**WELWYN HATFIELD BOROUGH COUNCIL
EXECUTIVE DIRECTOR - PLANNING, PUBLIC PROTECTION AND GOVERNANCE**

DELEGATED APPLICATION

Application No: 6/2018/0687/HOUSE
Location: 5 Bell Lane Brookmans Park Hatfield AL9 7AY
Proposal: Reconfiguration of first floor with revised roof shape and fenestration
Officer: Mr William Myers

Recommendation: Refused

1:50 & 1:100	11-08-17	NP
THE FORGE, 5 BELL LANE, BROOKMANS PARK, HERTS AL9 7AJ		
FIRST FLOOR & ROOF PLAN AS PROPOSED		
1678	02	Rev. B

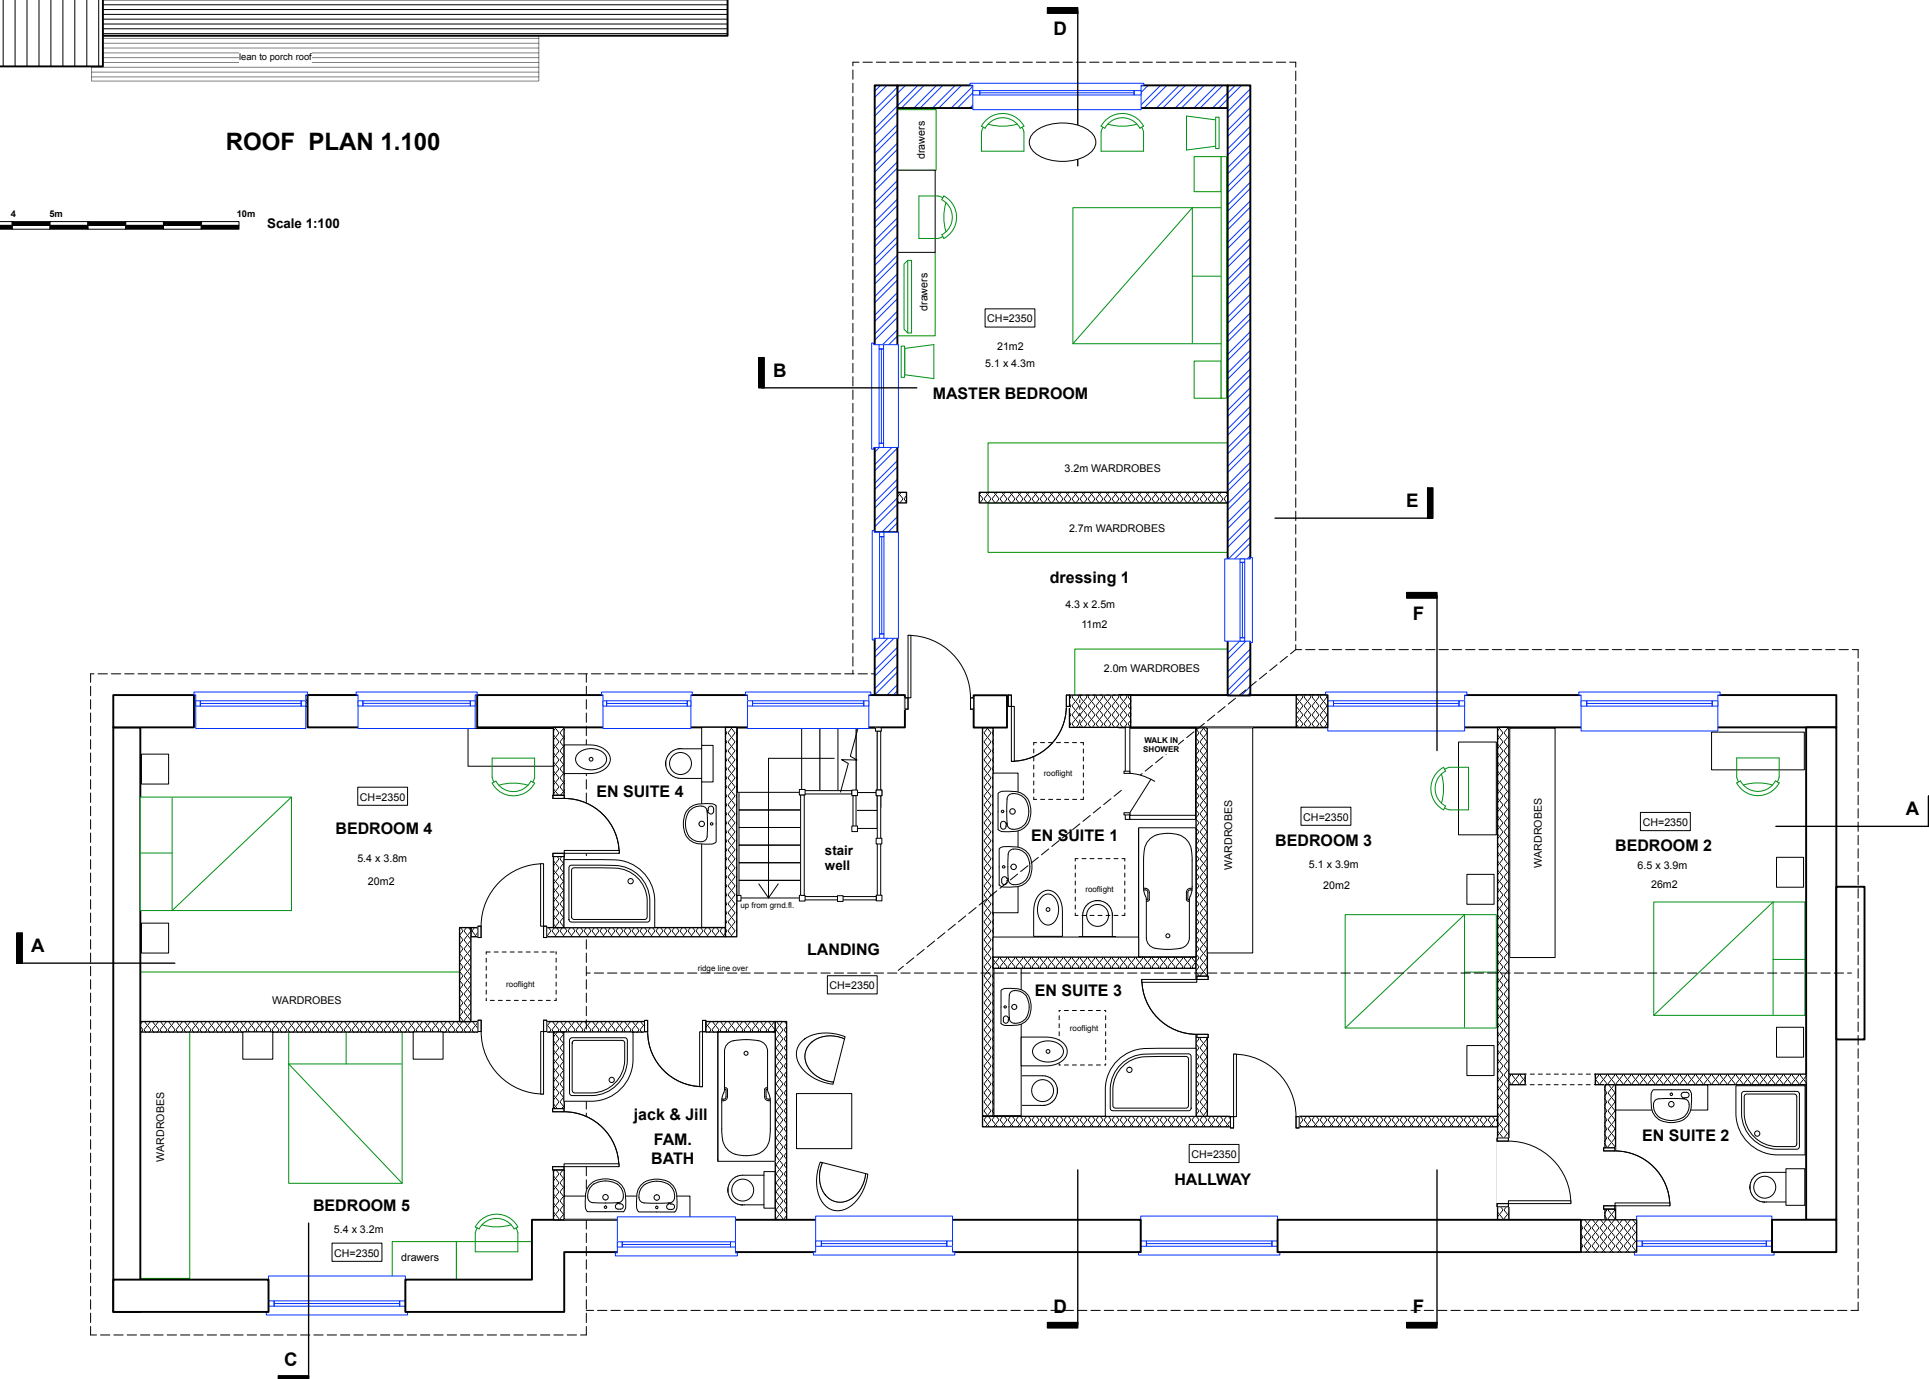
The planning records demonstrate that the original building, as granted permission in 1962, had a floor area of approximately 213m² and it was a single storey bungalow with a height of approximately 4.1m. In 2007 permission was granted for reduction in the overall foot print of the building but for the increasing of the ridge height of the bungalow by 2 metres and for habitable accommodation to be created in the extended roof space. It is important to note that although permission was granted on this basis, the site visit and application drawings indicate that the existing dwelling on site does not accord with the approved drawings. This is because the submitted plans for this application show the existing building has a footprint of 214m² and the applicant's own calculations for the existing building state that the footprint of the building is 214m². Another important point to address here is that the applicant has stated within their supporting document titled 'Comparative Areas & Volumes' that the existing external area of the first floor of the property is 214m², it is unclear how this figure has been arrived at because the submitted plans do not demonstrate this. Instead when these plans are measured they demonstrate that the external area at first floor level measures approximately 180m². As the proposed extensions would increase the external area at first floor level by 36m², the proposed extensions and alterations would result in the extended building having a total external area at first floor level of approximately 214m². When this increase is added to the previous extensions it would result in the proposed dwelling having a floor area which would be 100% larger than that of the original building.

Further to the above discussions about the proposed increases, it is considered that the proposed additions to the existing dwelling, which has already been significantly extended, would have a harmful impact on the openness of Green Belt. The proposed extensions would harm the openness of the Green Belt due to its impact in terms of prominence, size, bulk and design on the character and appearance of the area. These points are discussed in further detail within the following section of this report. The essential characteristics of Green Belts are their openness and their permanence and the loss of openness in the Green Belt resulting from the proposed extensions would conflict with this essential characteristic. Significant weight must be attached to this loss of openness.

The proposal would add further development to an already disproportionately extended dwelling. For the reasons discussed, the proposal fails to meet the exceptions set out in paragraph 89 of the NPPF. It would, therefore, be inappropriate development in, and thus harmful to, the Green Belt. It would also conflict, with Local Plan Policy RA3 and emerging Policy SADM34, which seek, among other things, to ensure that extensions, either alone or cumulatively with other extensions, do not result in disproportionate additions over and above the size of the original dwelling. Furthermore, the increased

1:100	11-08-17	NP
<p>THE FORGE, 5 BELL LANE, BROOKMANS PARK, HERTS AL9 7AJ</p>		
<p>ELEVATIONS AND SECTIONS AS PROPOSED (with 15° & 20° roof pitches)</p>		
1678	04	Rev. B

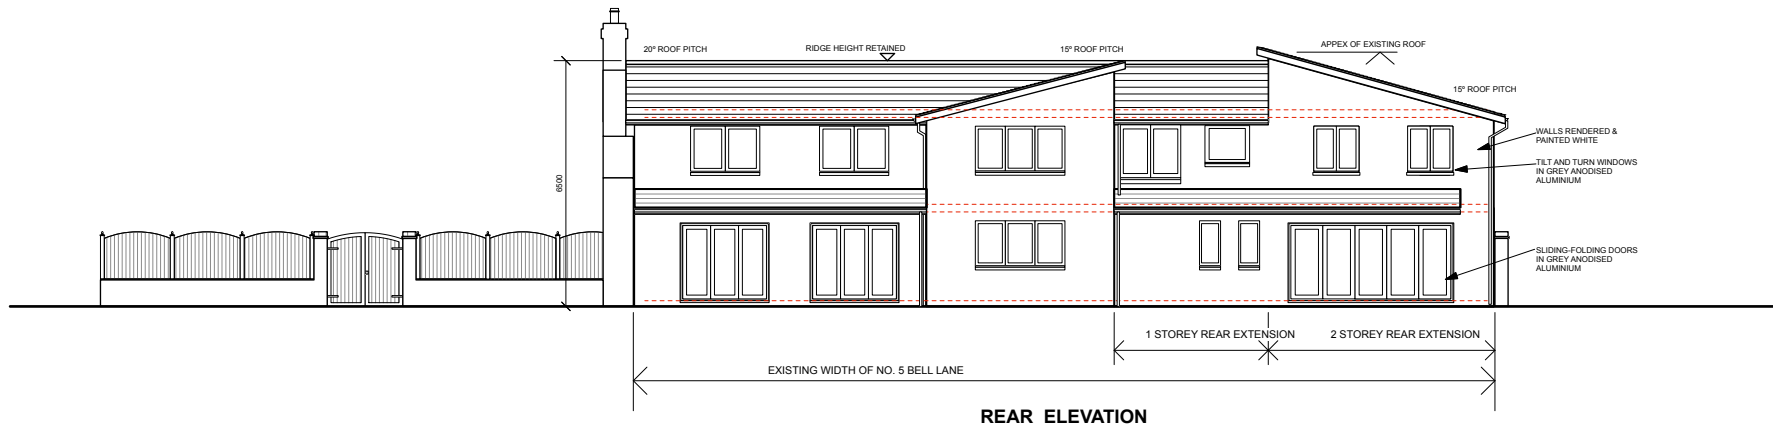
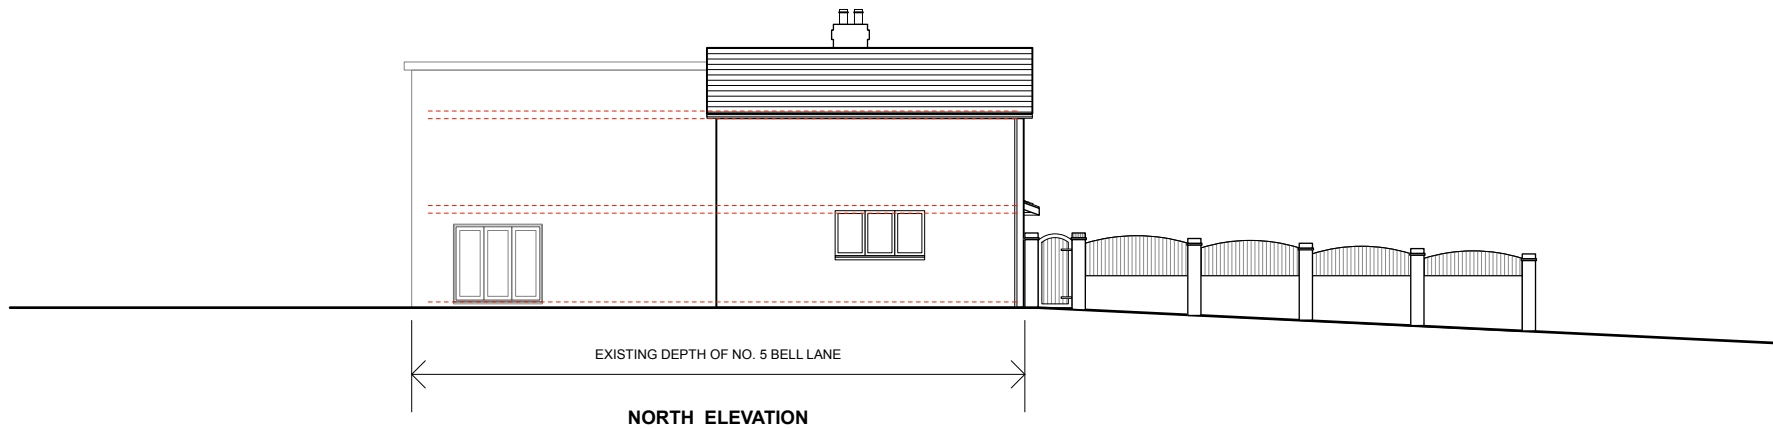
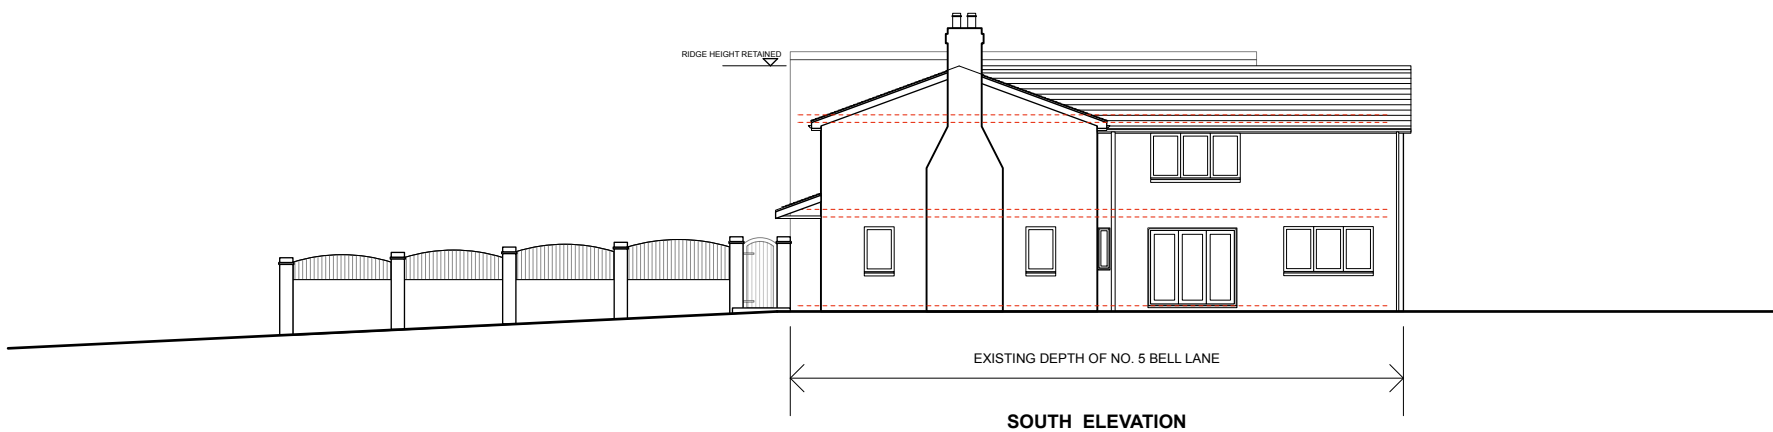
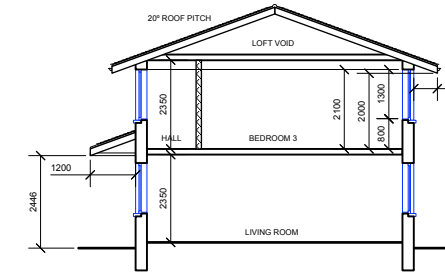
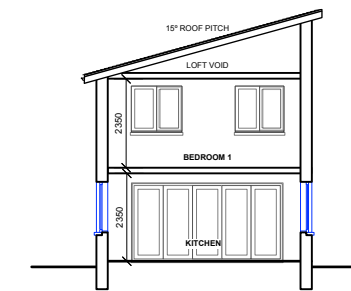
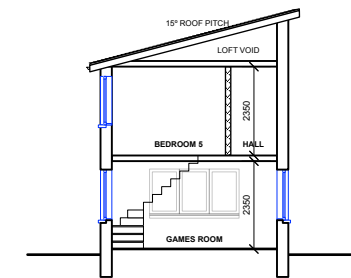
<p>bulk and massing of the proposed development would result in a loss of openness and visual permeability of the Green Belt.</p>
<p>Design (form, size, scale, siting) and Character (appearance within the streetscene)</p>	<p>Local Plan Policies D1 and D2 aim to ensure a high quality of design and to ensure that development respects and relates to the character and context of the locality, maintaining and where possible enhancing the character of the existing area. These policies are expanded upon in the Council's Supplementary Design Guidance (SDG) which requires the impact of a development to be assessed giving regard to the bulk, scale and design of the proposal and how it harmonises with the existing building and area. These objectives are broadly consistent with a core principle of the NPPF which states that good design is a key aspect of sustainable development, is indivisible from good planning, and should contribute positively to making places better for people.</p> <p>Proposed extensions would maintain the existing height of the building but result in extensions a first floor level that would change the existing chalet bungalow into a two storey dwelling and make the first floor level the same size as the ground floor. In addition, proposals would significantly reduce the pitch of the main roof and would change the roof slope on the eastern flank of the building from a dual pitched roof to a mono pitched roof, which would slope in an easterly direction. These changes would fundamentally alter the character of the dwellinghouse on the site, by creating a dwelling that would be substantially different to the modest chalet bungalow which currently exist. For these reasons the proposed increases in the bulk and scale of the dwelling at first floor level would not amount to additions that would be subservient or subordinate to than the existing building. In addition, the proposed external material of the dwelling and fenestration pattern would be significantly different to the existing dwelling. Although such materials and fenestration detailing may be acceptable in some cases it is considered that in the case these changes are another indication of how the proposed development would fundamentally alter the character of the existing dwelling.</p> <p>Overall the proposed development would be excessive in size and would represent a poor standard of design with the result that it is contrary to the NPPF and Policies D1 and D2 of the District Plan which attach great importance to the design of the built environment and the SDG which seeks a design led approach to development.</p>

2. The proposed extensions would be of a poor quality of design and they would insufficiently reflect the design and character of the host dwelling. In addition, the extensions would not be subordinate or subservient to the existing building and would be excessive in size. Accordingly, the proposal is contrary to the National Planning Policy Framework 2012, Policies D1 and D2 of the Welwyn Hatfield District Plan 2005 and the Supplementary Design Guidance 2005.
